DEVELOPMENT REVIEW BOARD - HYDROLOGY SECTION
 Renée Brissette, PE, Senior Engineer | 505-924-3995 rbrissette@cabq.gov

DRB Project Number: 1011569 Hearing Date: 04-04-2018
 Project: Parkland Hills, Lots 1, 2 ,3 ,15, & 16, Block 25 Agenda Item No: 14

PLAT OF LOTS 1-A & 1-B, BLOCK 25 PARKLAND HILLS

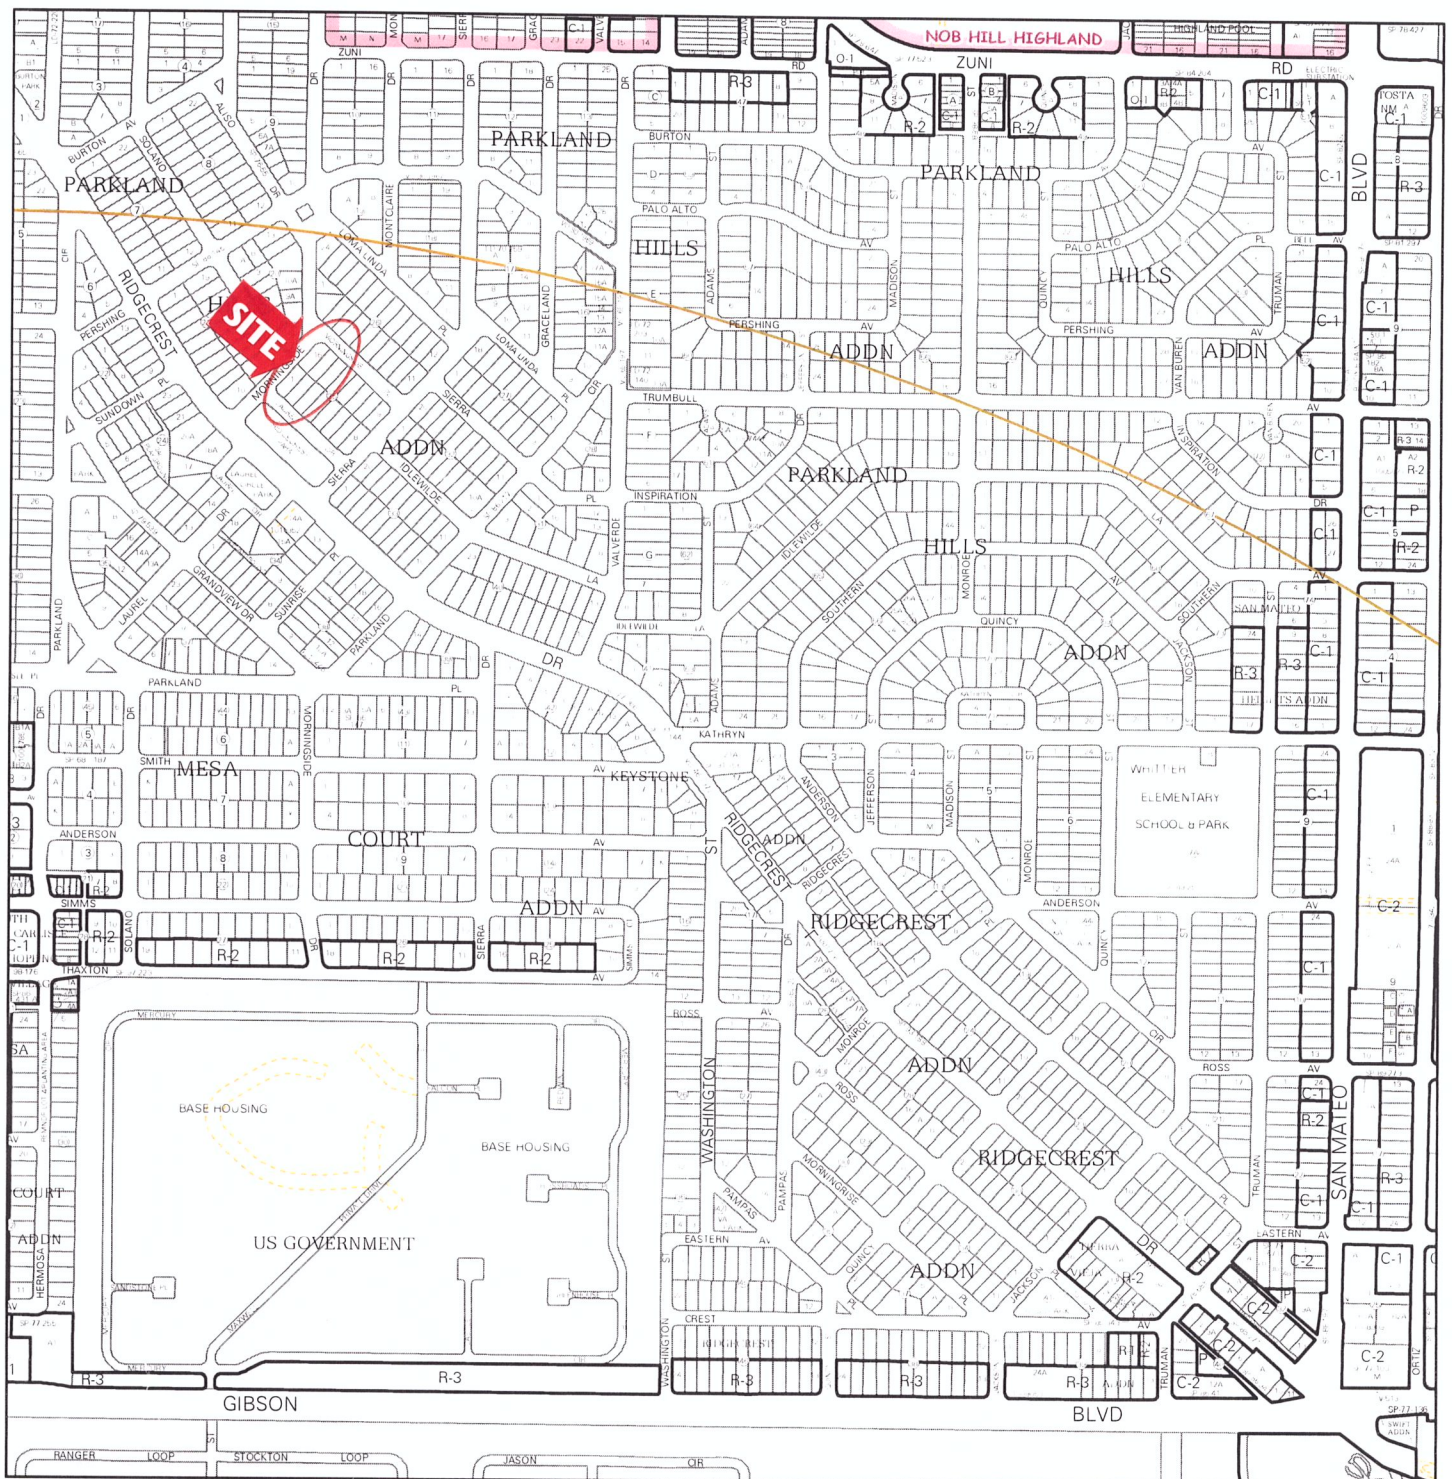
- Cross Lot Drainage Easement note specifying the beneficiary and maintenance agreement must be added to the plat.
- For Information - Approved grading and drainage plan is required prior to Building Permit if one of these conditions is met. (500 cy of grading, 1,000 sf of proposed building , or 2,000 sf of proposed paving).
